## **Application by Highways England for TR010031: A1 Birtley to Coal House Improvement Scheme**

### **The Examining Authority's written questions and requests for information (ExQ1)**

**Issued on 28 January 2020**

### Applicant's Responses to ExA's First Written Questions – Appendix 1.0.D - Main Phases of Construction Works and Scheme Areas

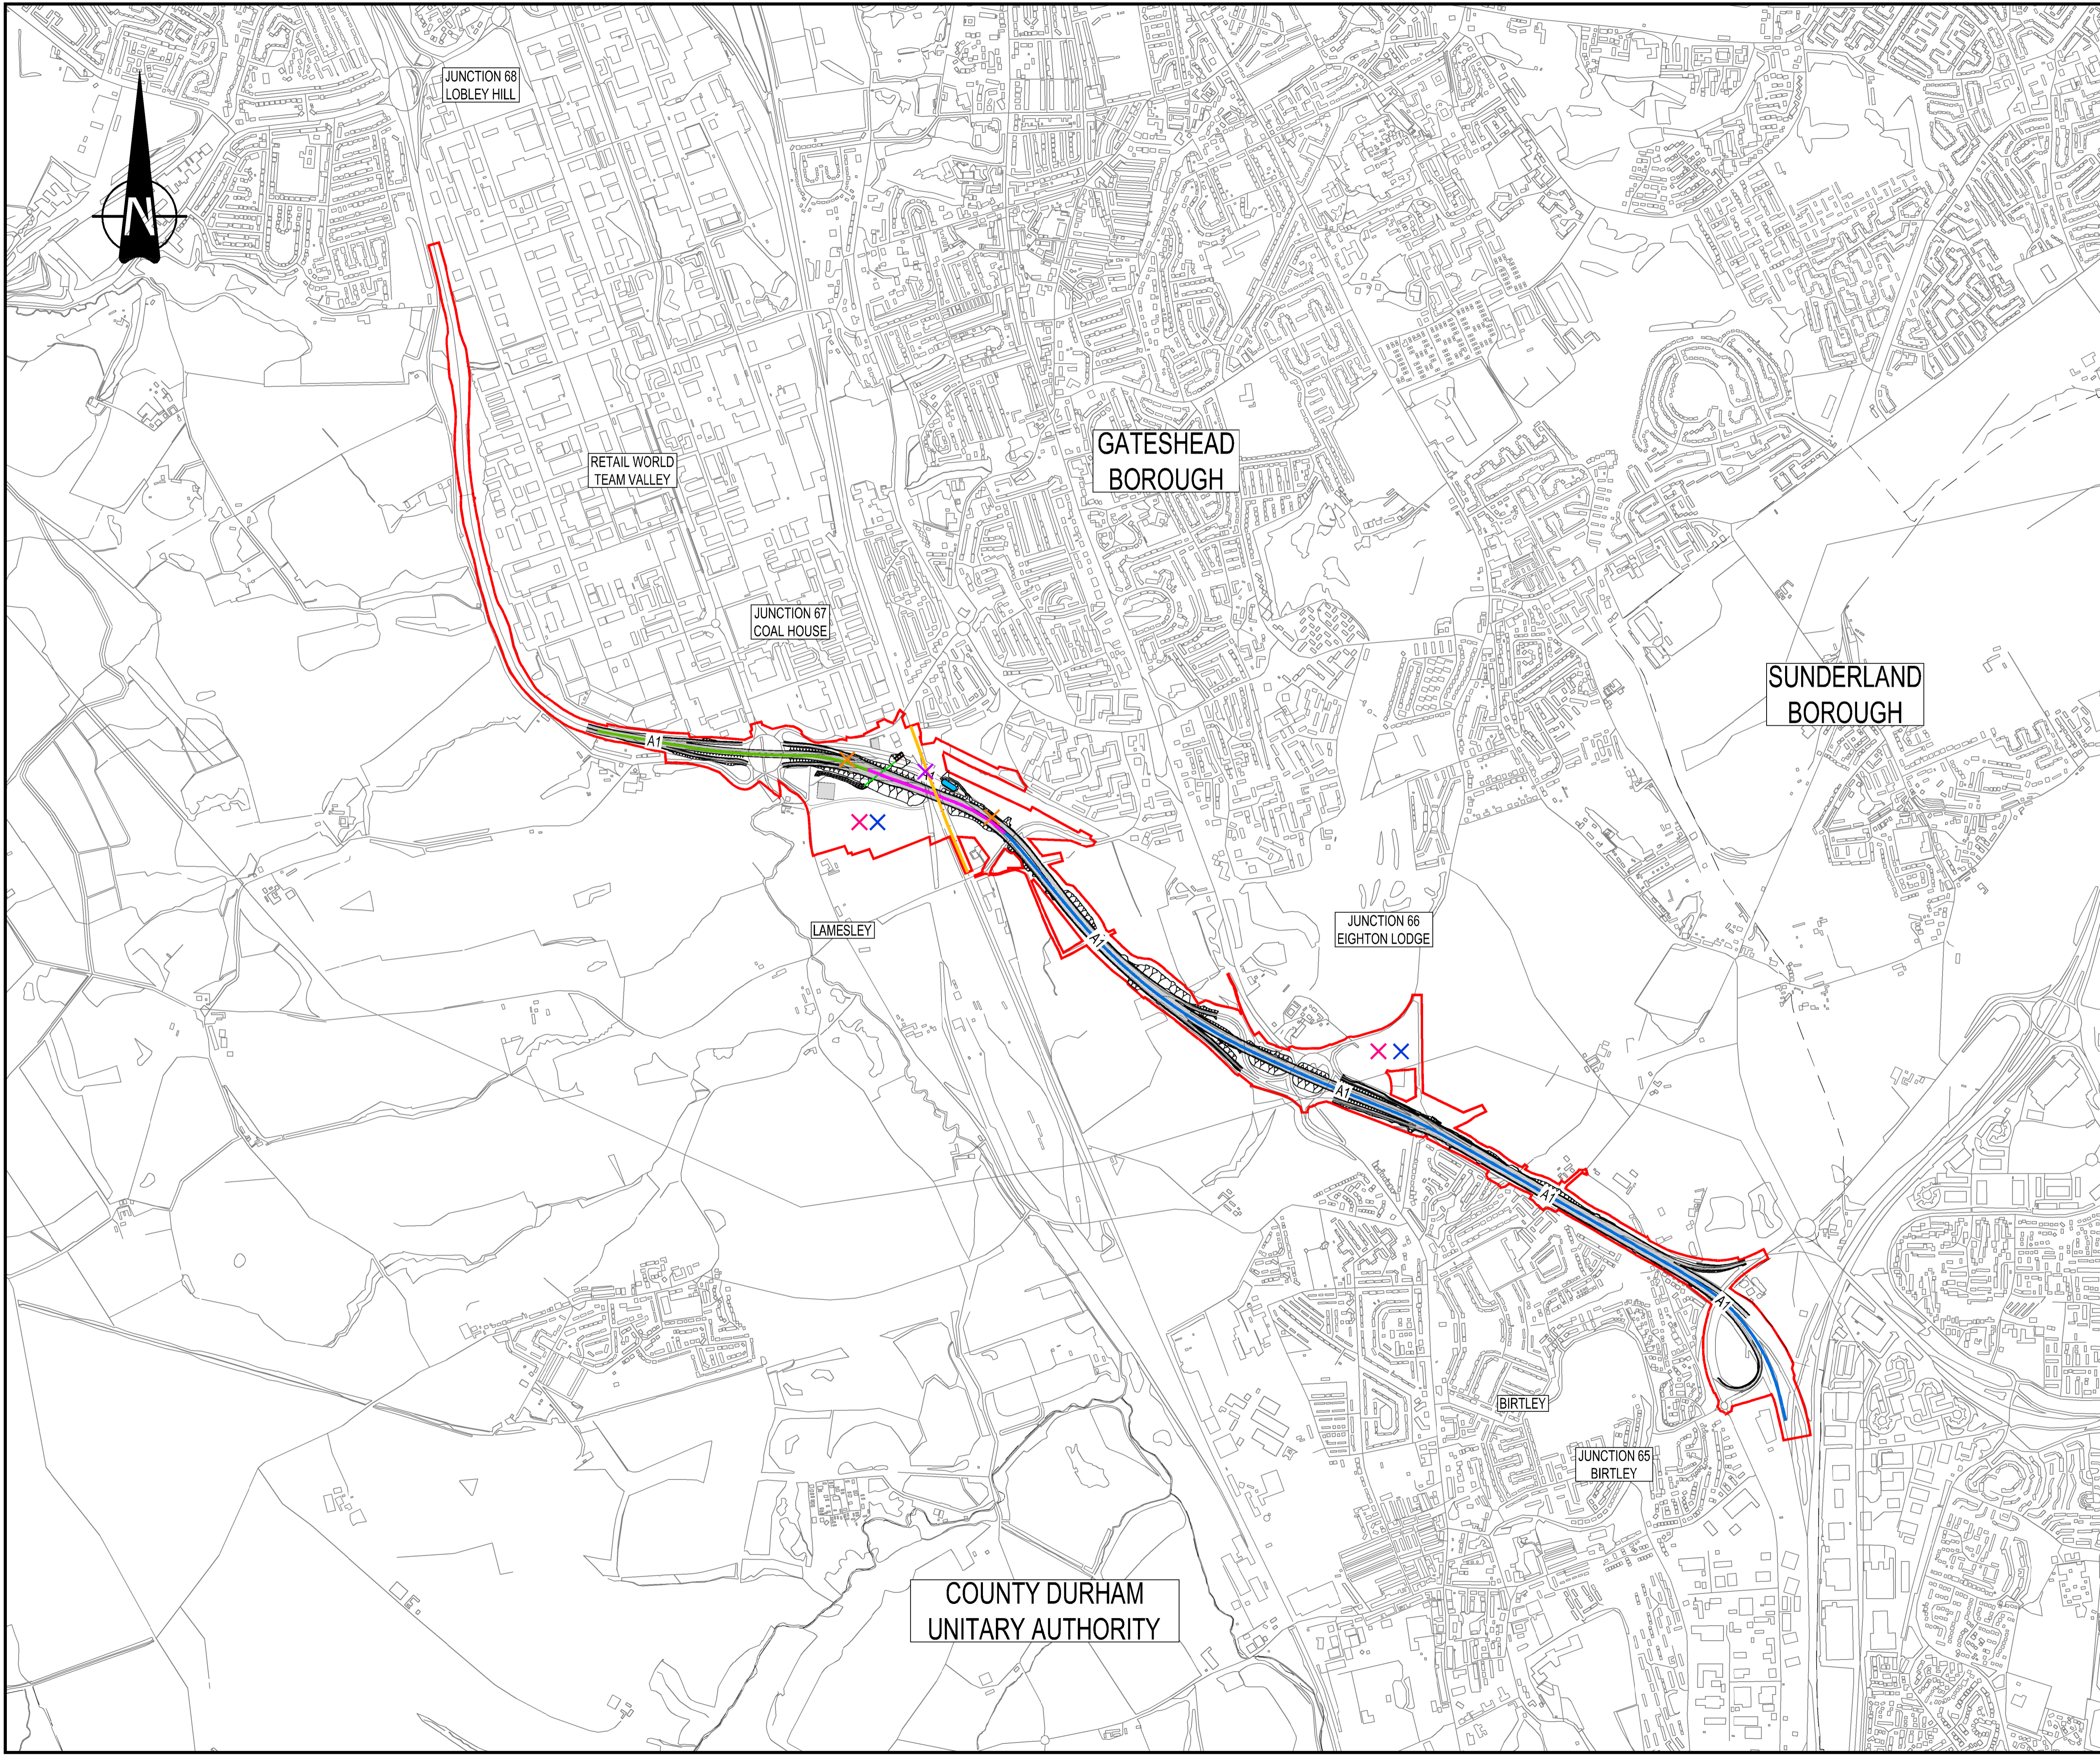
| ExQ1   | Question to: | Question:  |
|--------|--------------|--|
| 1.0.10 | Applicant    | <p>Table 2-5 (Main phases of construction work) of the ES [APP-023] includes start and end dates including for the 'demolition of existing Allerdene Bridge' (Area 2) and 'removal of existing Allerdene Bridge and Approaches' (Area 7).</p> <p>What are the differences between these two components of work? Explain how both components of work have been assessed in the ES?</p>  |
